Application no: 23/00977/OUT

Location: OS Parcel 9195 North Of, Claydon Road, Cropredy

Transport Schedule

Title :
Proposed Site Access & Visibility Splays

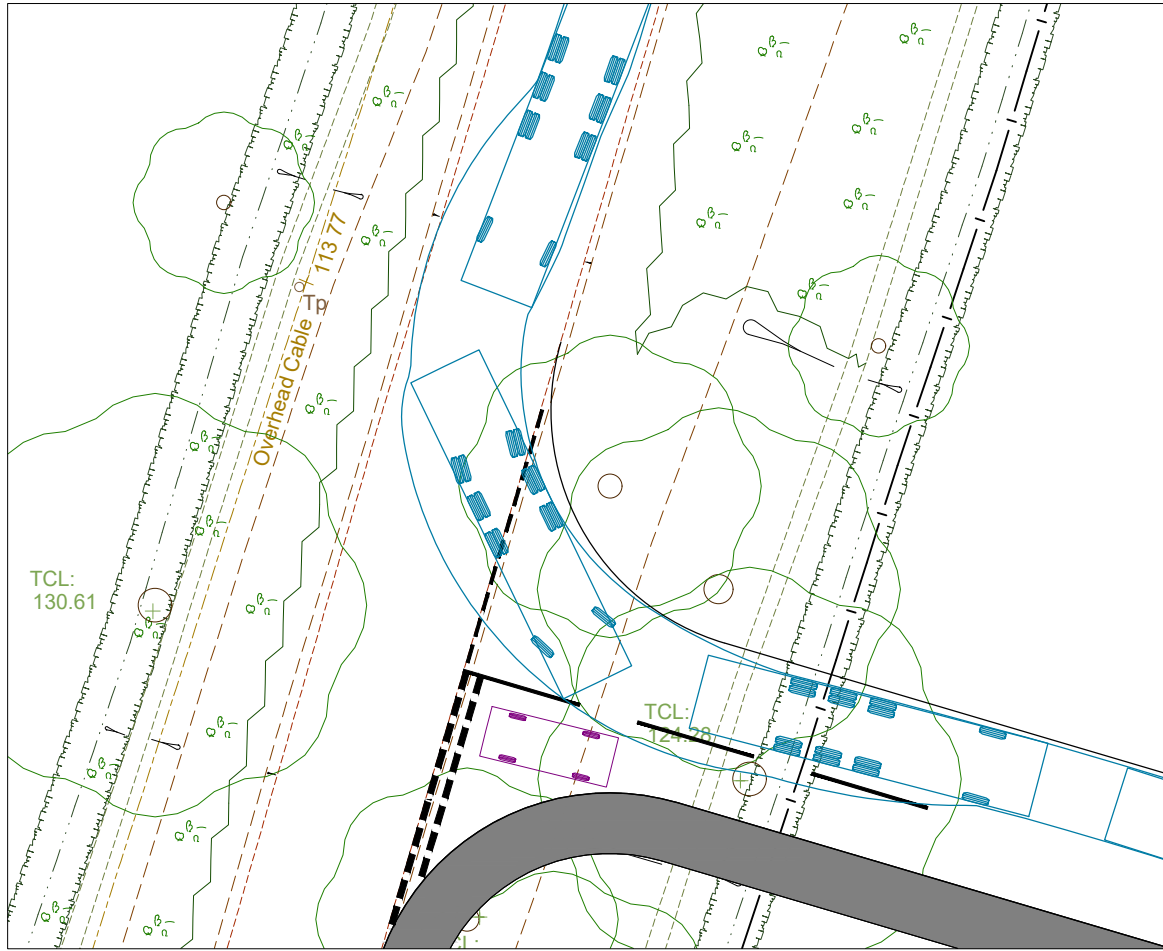
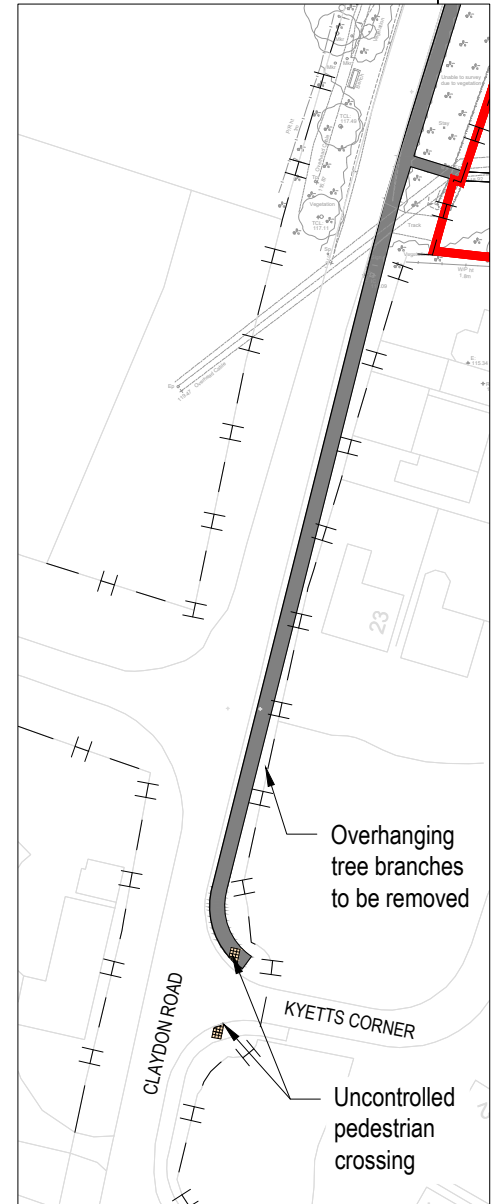
A revised plan has been provided, annotated to show that levels within the site would be made up to ensure a gradient no steeper than 1:20 on the access road. This plan also

shows the new footway from the access to link with existing footway, which the developer will be required to deliver as part of the S278 works.

It is also noted that a pedestrian access is proposed at the southern corner of the site, which should be labelled as such.

The TS proposes (para 4.9) a village gateway feature. Given the high approach speeds, this should be a stronger feature. In accordance with OCC policy, a 20mph limit for Cropredy has been consulted on and is due to be implemented, although no physical measures to enforce it are planned. The access plan should be amended to show indicatively a build out north of the site access, in the position of the speed limit change. This would be subject to consultation, along with the speed limit change.

The condition for access full details should be amended to include the footway and pedestrian connection, as well as the traffic calming feature:

Prior to the commencement of the development hereby approved, full details of the means of vehicular and pedestrian access between the land and the adopted highway, including new footway linking the site access to existing footway in the village, dropped kerb crossing of Kyetts Corner, and traffic calming feature on Claydon Road to the north of the site access, including position, layout, construction, drainage and lighting, in broad accordance with indicative plan XXXXX shall be submitted to and approved in writing by the Local Planning Authority. Thereafter and prior to first occupation these works shall be constructed and retained in accordance with the approved details.

Swept Path Analysis

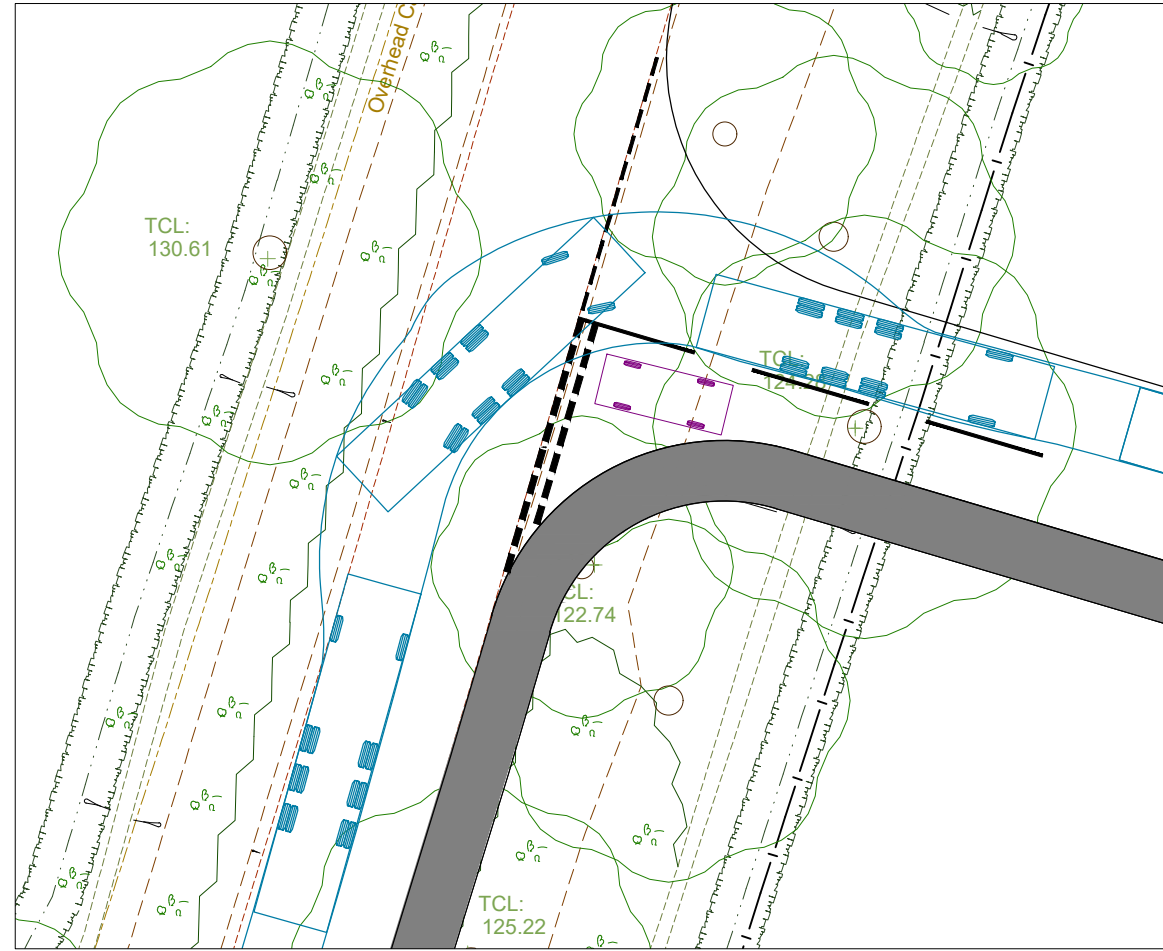
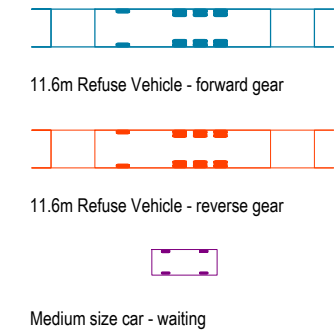
The response document justifies the swept path of the refuse vehicle entering the opposing lane at the site access, based on the low traffic volumes on Claydon Road. With the speed limit reduction, I am satisfied that this will be acceptable, albeit slight tweaks to the layout may be required at S278 technical audit stage.
